Address: 262 Barnsley Road Wakefield WF4 4AJ

Application number: 2024/92066	
What is the application for?:	Outline application for erection of dwelling
Address of the site or building:	Land Adj, 264, Barnsley Road, Flockton, Wakefield, WF4 4AJ
Postcode:	WF4 4AJ

title site plan  
number 24065D-01-P01  
scale 1:200  
size A2

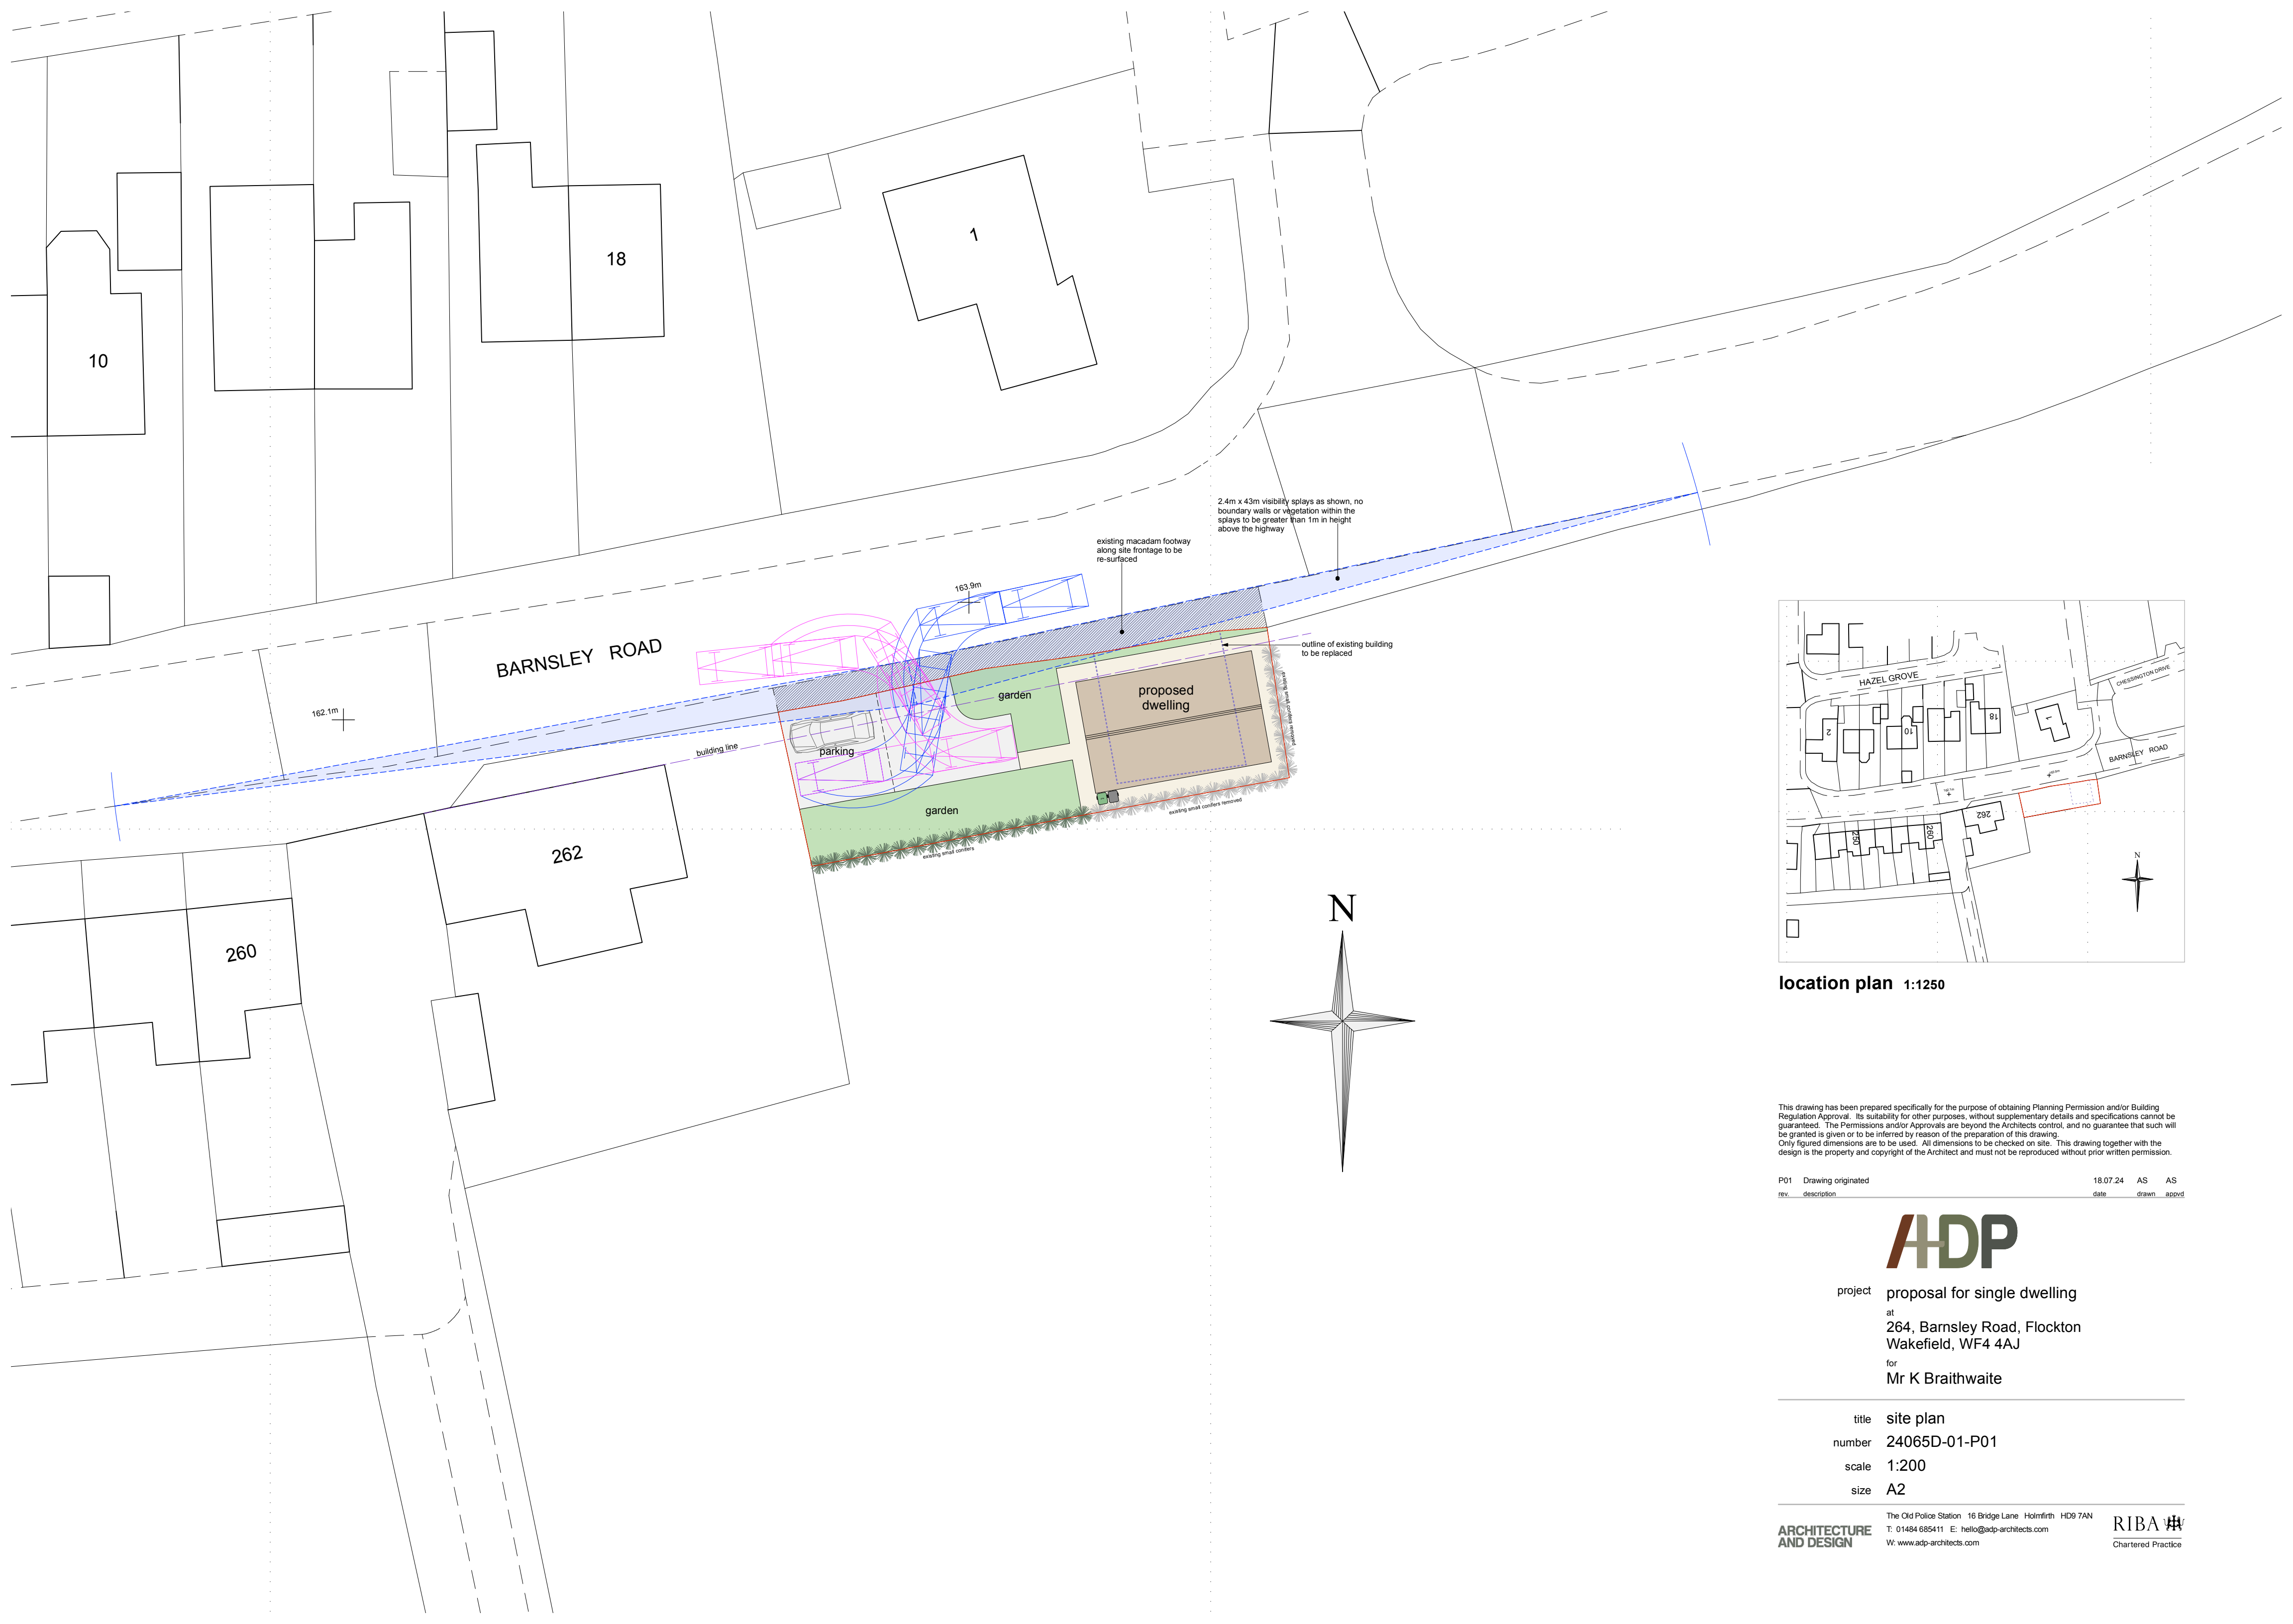
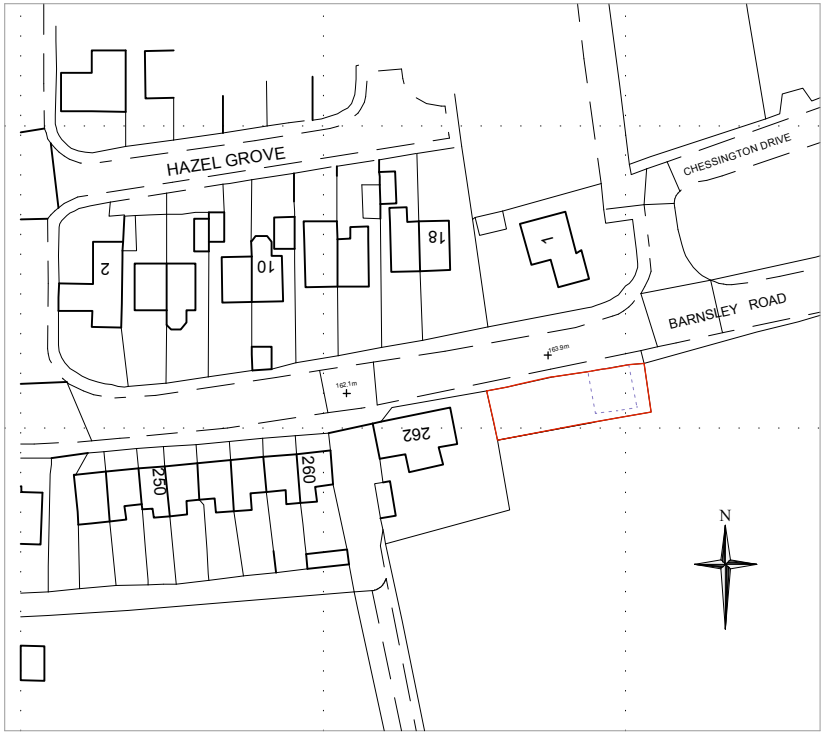
Type of comment: A general comment	
Do you wish your comments to be published on the website anonymously?	<input type="checkbox"/> No
<p>I live adjacent to the proposed application. I note that there is access for parking and a slight extension of the current building boundary. I would like to ask how high the proposed building will be? Also as to what will be built at the front roadside i.e at the boundary between the land and the road. The reason I raise these is because I need to be able to see up the road so I can safely pull out of my drive and I want to make sure the visibility remains adequate.</p>
